**CHENNAI METROPOLITAN DEVELOPMENT AUTHORITY**

E-mail: mcmda@tn.gov.inWeb site: www.cmdachennai.gov.in**Letter No. L1/4397/2016****Dt 09.01.2017**

Sub: CMDA - Area Plans Unit - Layout Division - Planning Permission Application - Sub - Division of house sites in S.Nos. 395/1A2A & S.No.1A2B, Perungalathur Village, Tambaram Taluk, Kancheepuram District, Perungalathur Panchayat Union limit - Development Charge and other charges to be remitted - Reg.

SUB-DIVISION OF HOUSE SITES IN S.No: 395 / 1A2A & 1A2B OF PERUNGALATHUR VILLAGE.

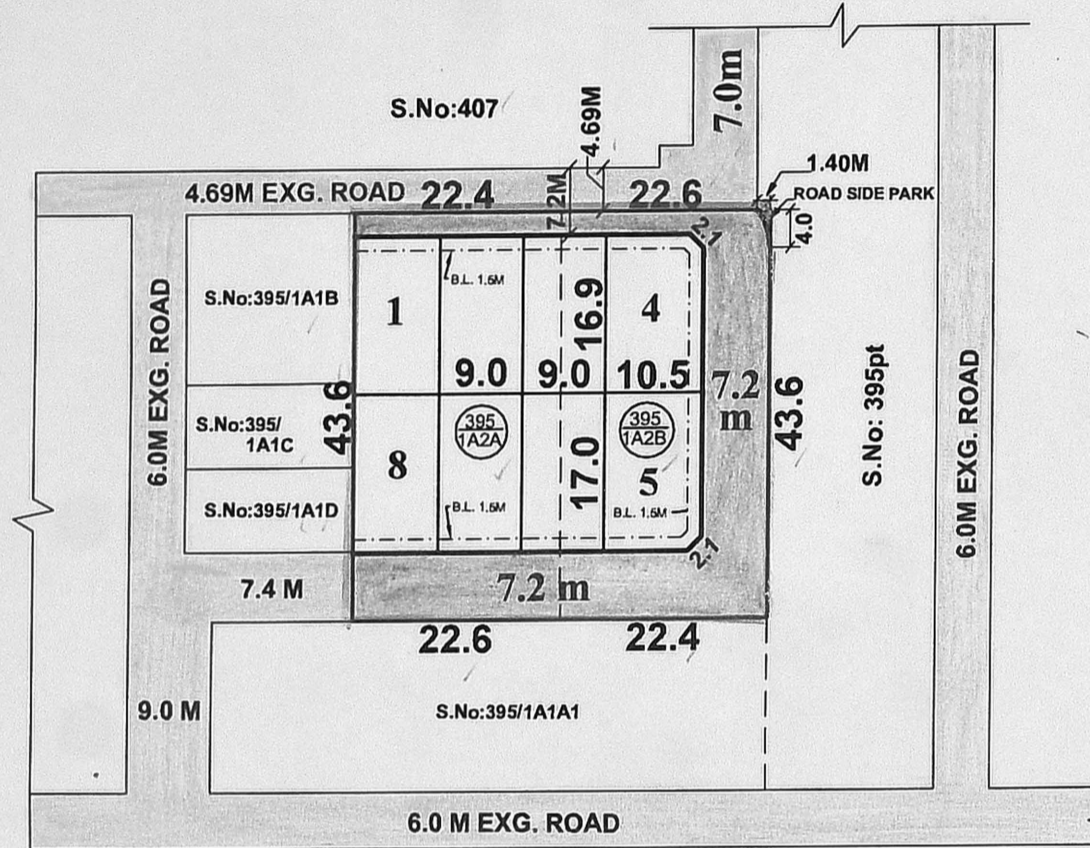
The proposal received in the reference 1st cited for Sub - Division of house sites in S.Nos. 395/1A2A & S.No.1A2B, Perungalathur Village, Tambaram Taluk, Kancheepuram District, Perungalathur Panchayat Union limit was examined and layout has been revised to satisfy the Development Regulation requirements and taking into account of the existing developments around / future demand for circulation in the area. You are requested to remit the following charges by three separate Demand Drafts of a Nationalized Bank in Chennai City drawn in favour of **Member Secretary, CMDA, Chennai-8**, at cash counter (between 10.00 a.m. to 4.00 p.m.) in CMDA and produce the duplicate copy of the receipt to the Layout Division in CMDA or you may also remit the following charges through online gateway payment in Indusind Bank A/c.No.100034132198 & IFSC Code No.INDB0000328 and inform the same to this office.

5. You are further requested to obtain NOC from WRD (PWD) on the aspect of inundation of the site under reference and also for the construction of culvert across the field channel existing in between the site and the abutting road and furnish the same to this office along with the DC & Other charges.
